From: Karen Parsons
Sent: 28 June 2018 11:59
To: Planning.Responses
Subject: FW: Planning application fg/53/18/hh

We have put an objection to the building works for number 5 Barbary Lane Ferring bn12 5jb we live at 3 Barbary Lane.

DRWG NO 1

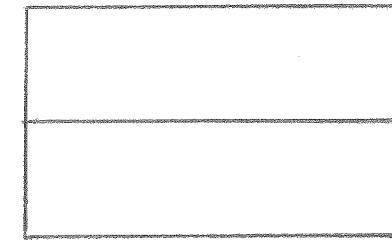
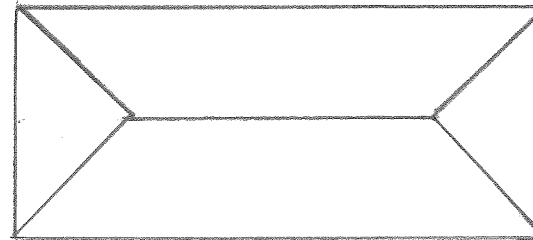
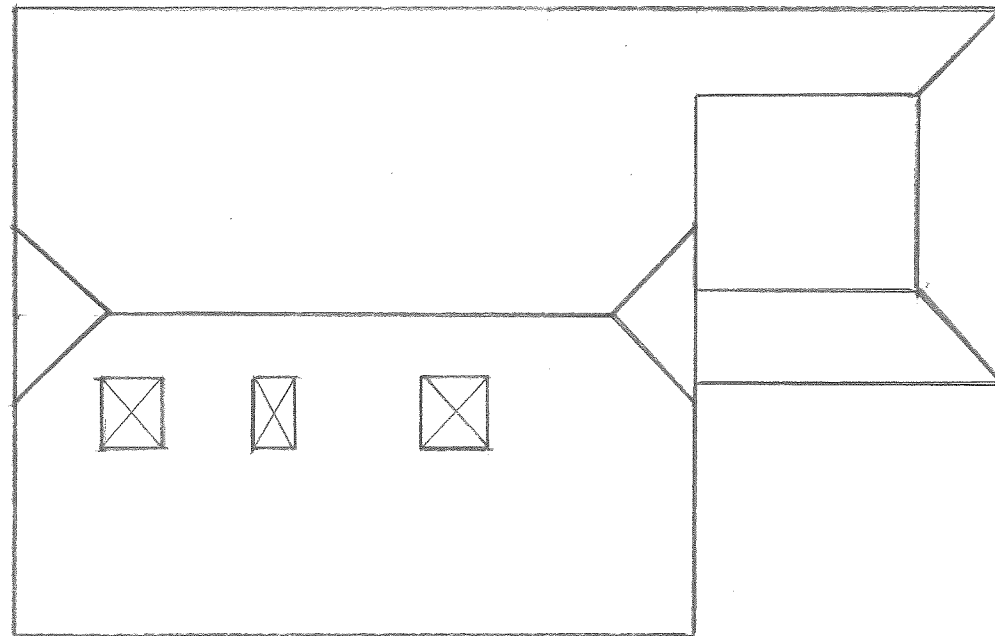
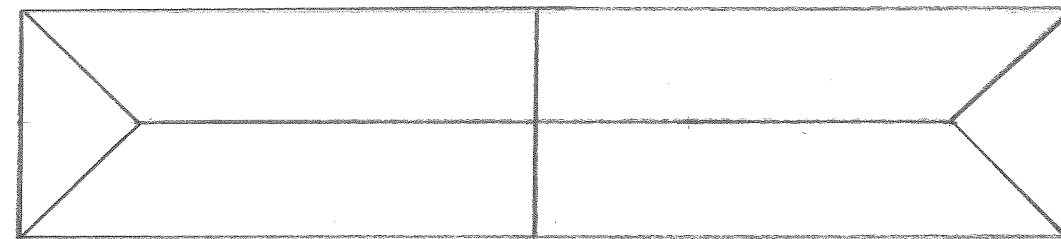
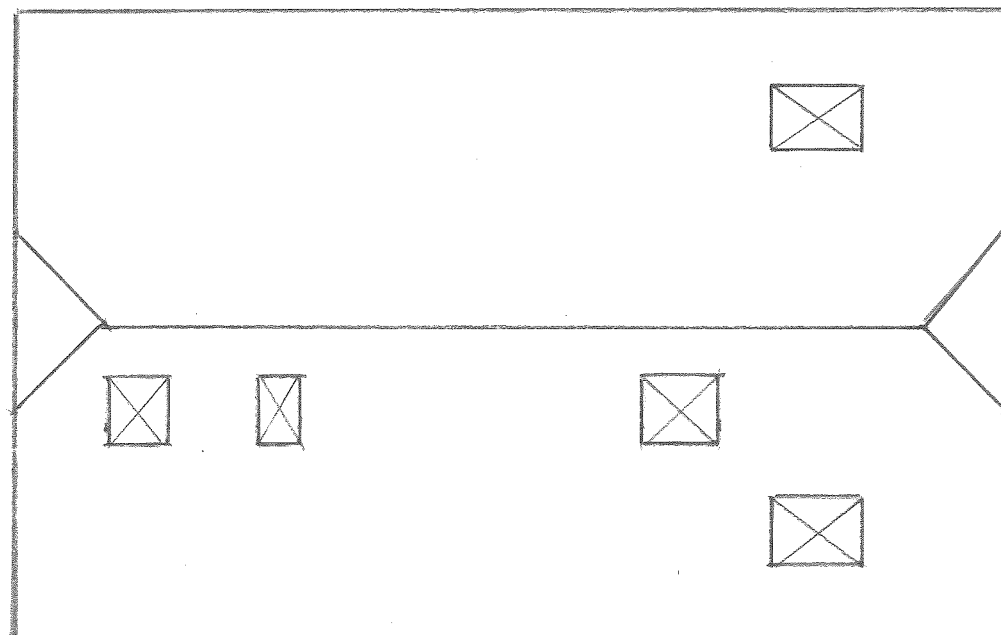
We did send some photo's to Mr Ross Leal as to the problem we might have should he be allowed to lift the shed roof to almost the garage height with the infill between the shed and garage and use concrete tiles which will be a total about 50' feet long which we feel wold be overbearing he tried to have the shed roof to the height of the garage when he first put it up some years back he was informed to reduce it after we submitted a complaint. So now it's on again he does not use his garage except for his carpentry and his machines so he would then have a extended workshop with extra machinery.

DRWG NO 2

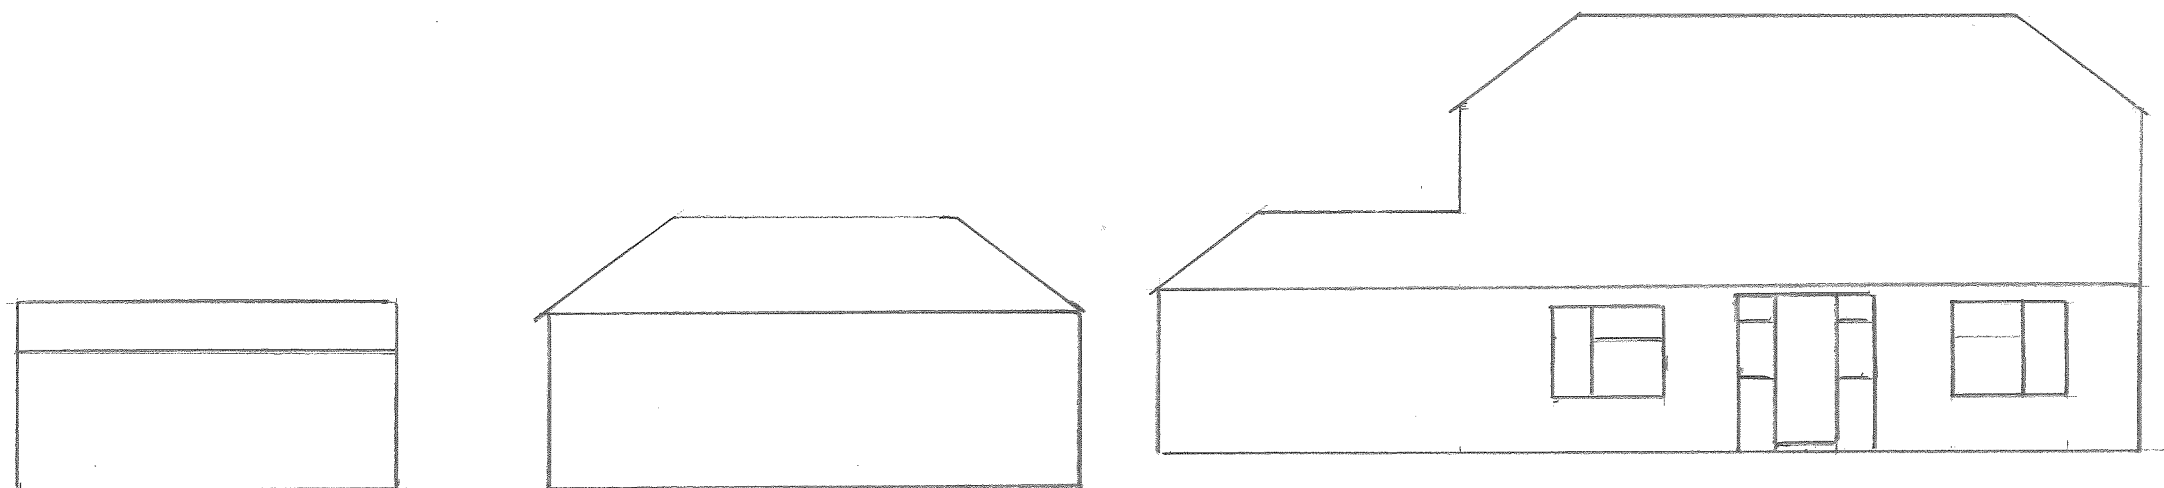
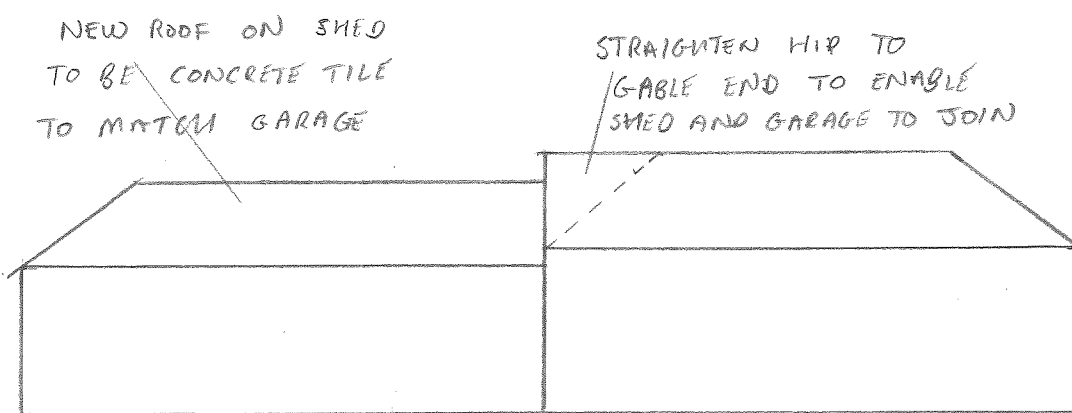
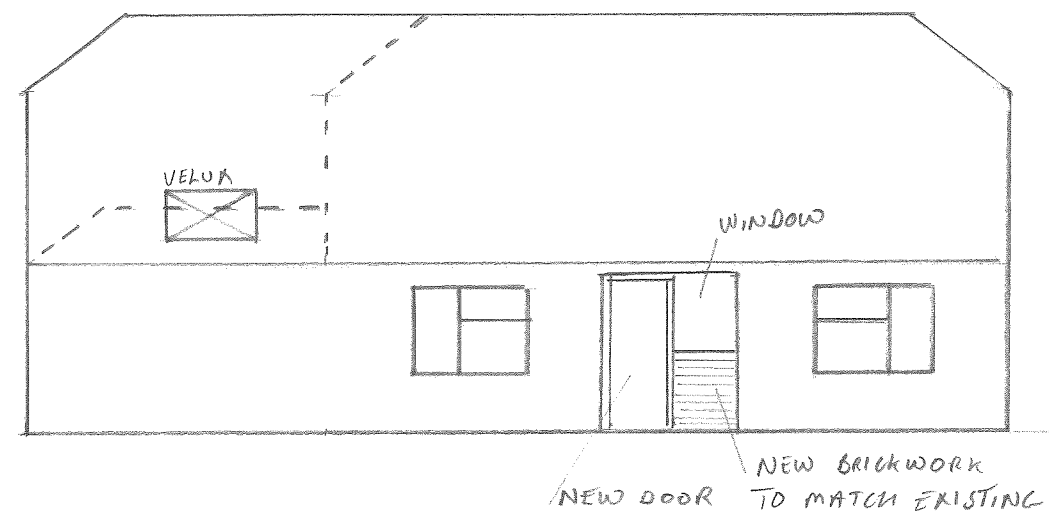
On the south elevation he intends to put a velex window into the south west corner of the roof which will invade our privacy by looking straight onto our patio and garden.
